**Re: Objection to Planning Application 2024/70/92167/W for Development at Land off Edgerton Road, Edgerton, Huddersfield, HD3 3AA.**

I am writing to formally object to the planning application for the proposed development at Clayton Fields. As a resident whose property borders the rear boundary of the development site, I have significant concerns regarding the adverse effects this proposal will have on both my property and the wider local area. My objections are as follows:

Project
Proposed Residential Development
Clayton Field
Edgerton
Huddersfield

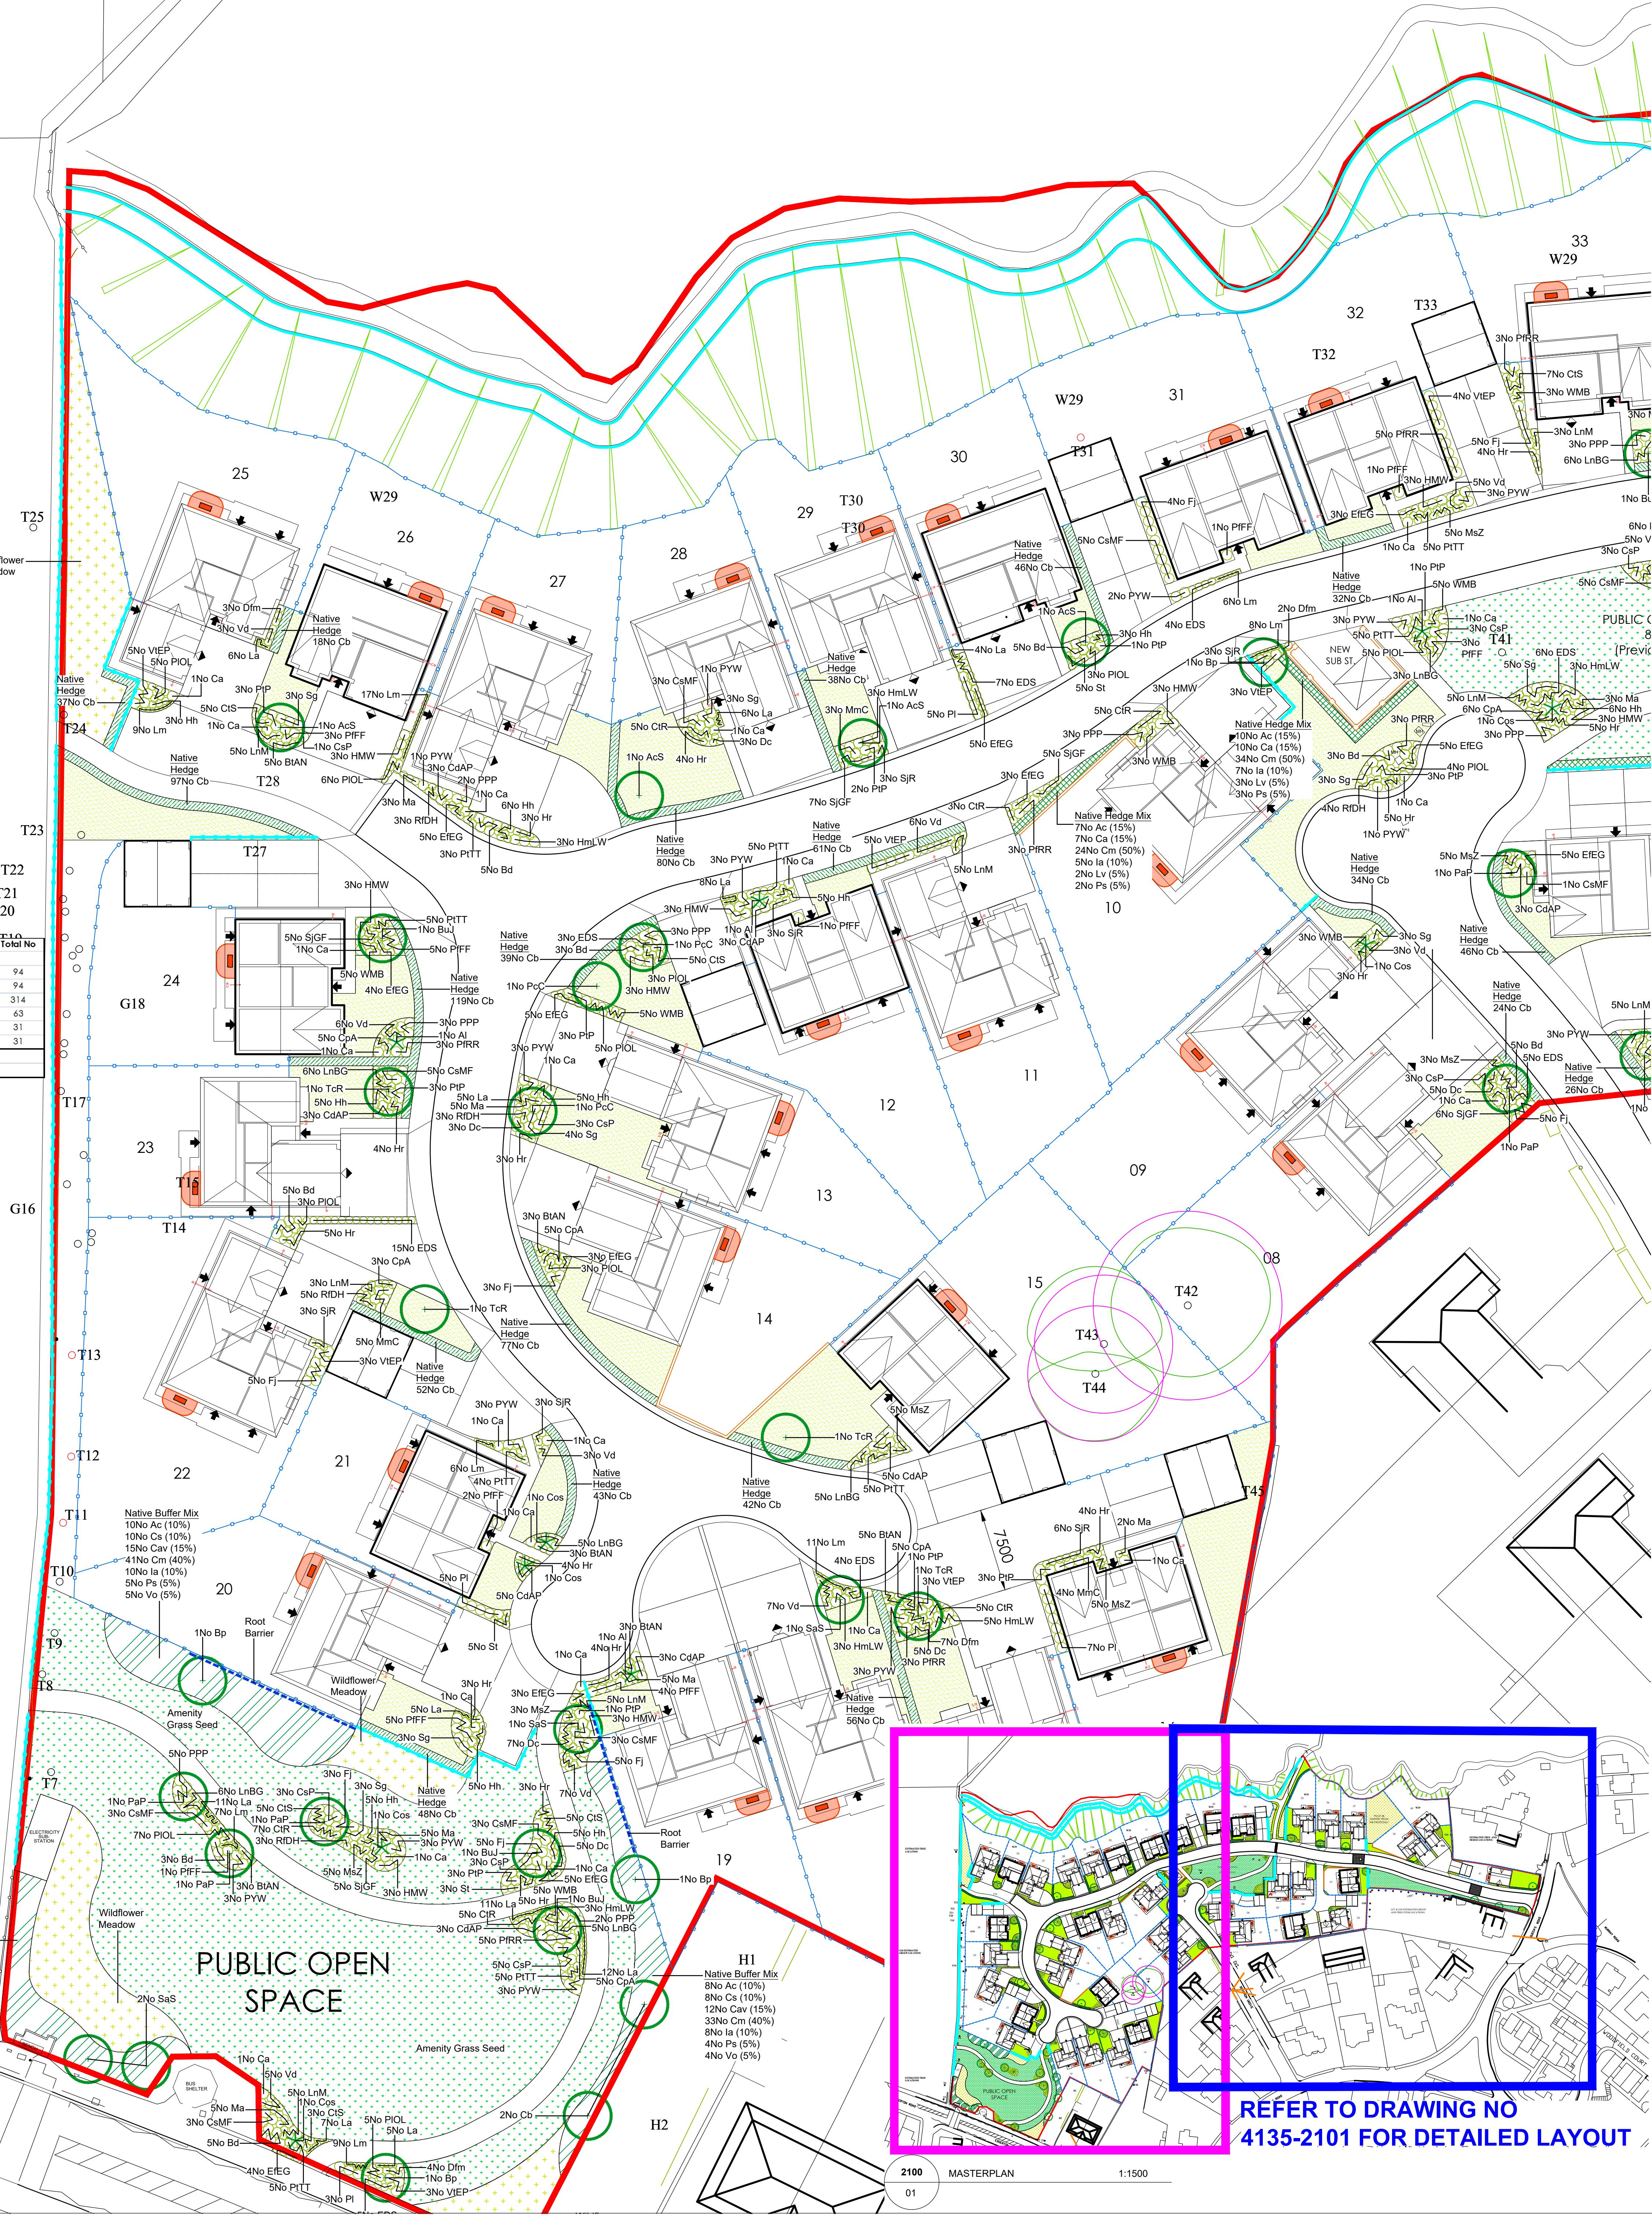
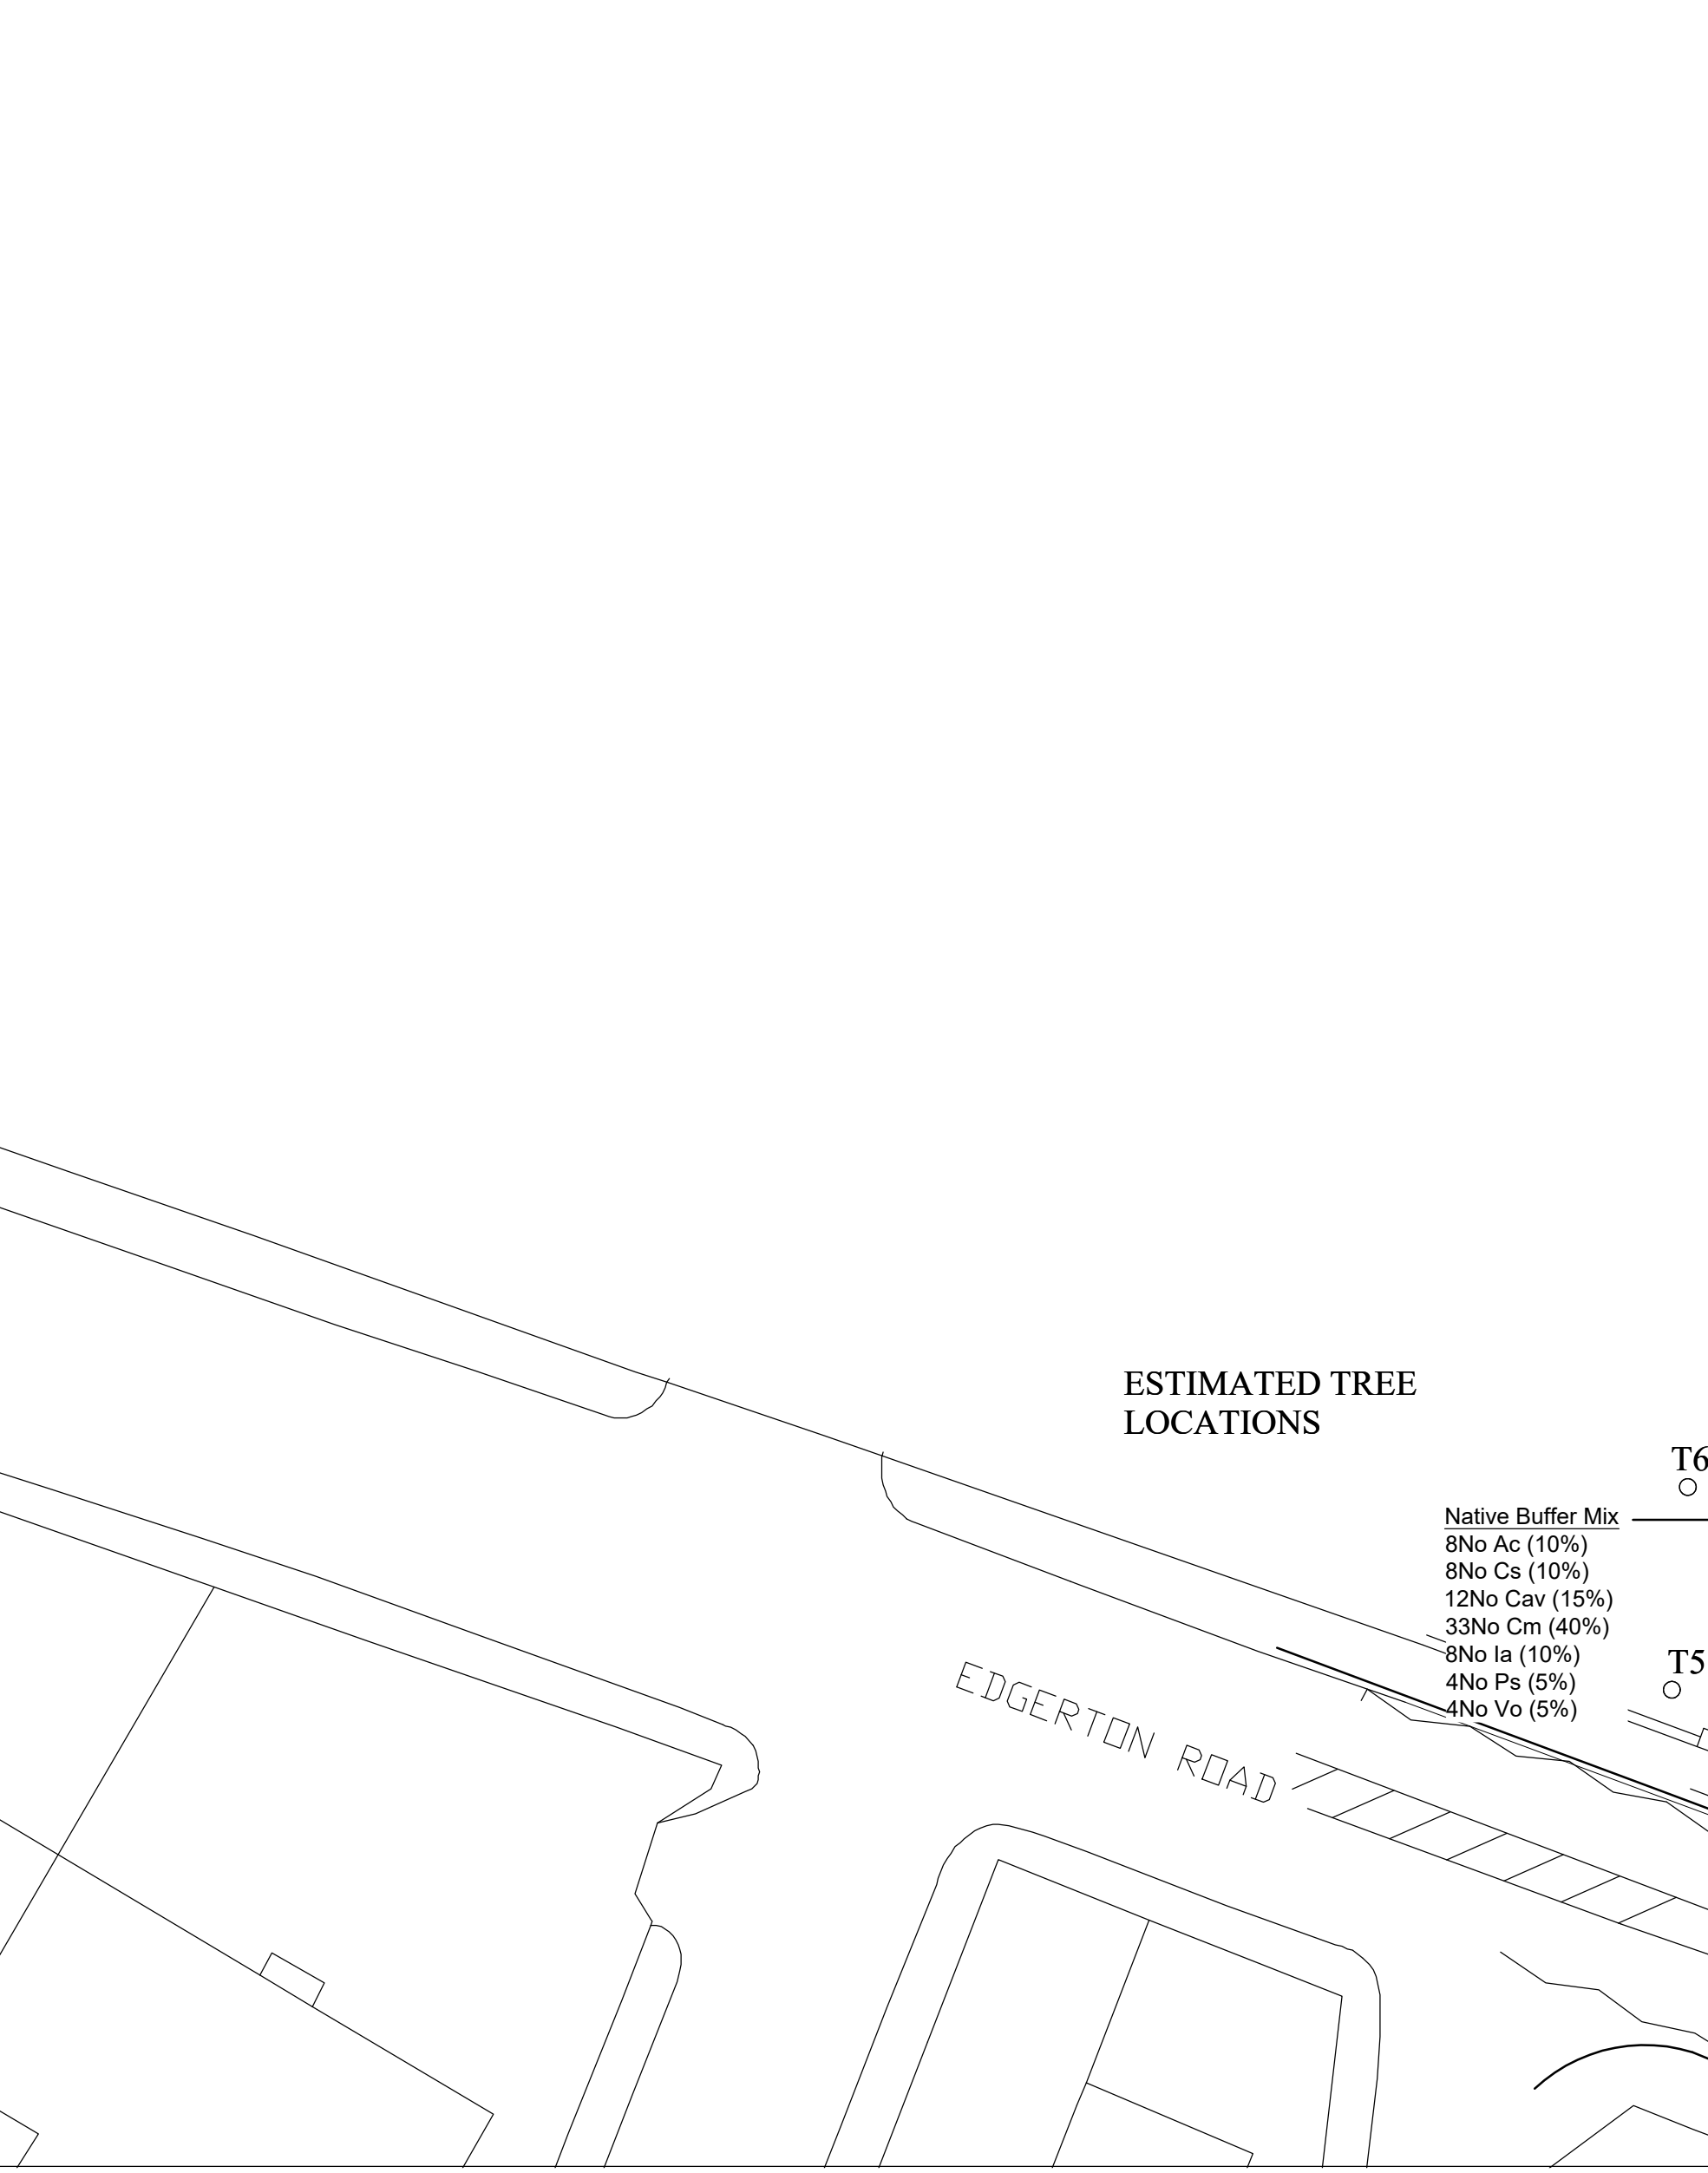
### **3. Felling of Mature Oak Trees and Environmental Impact**

The developer's application includes plans to fell two mature oak trees. A third mature oak tree near my boundary has already caused structural damage to the retaining wall, and when I requested permission to fell it several years ago, a Tree Preservation Order (TPO) was placed on it. The proposed development is already set to take away a large green space from the Edgerton Conservation Area, which will have detrimental effects on local wildlife and the environment. I strongly believe it is inconsistent and unjust to deny my request to remove a tree causing damage to my property while allowing a developer to destroy healthy, mature oak trees for purely financial gain.
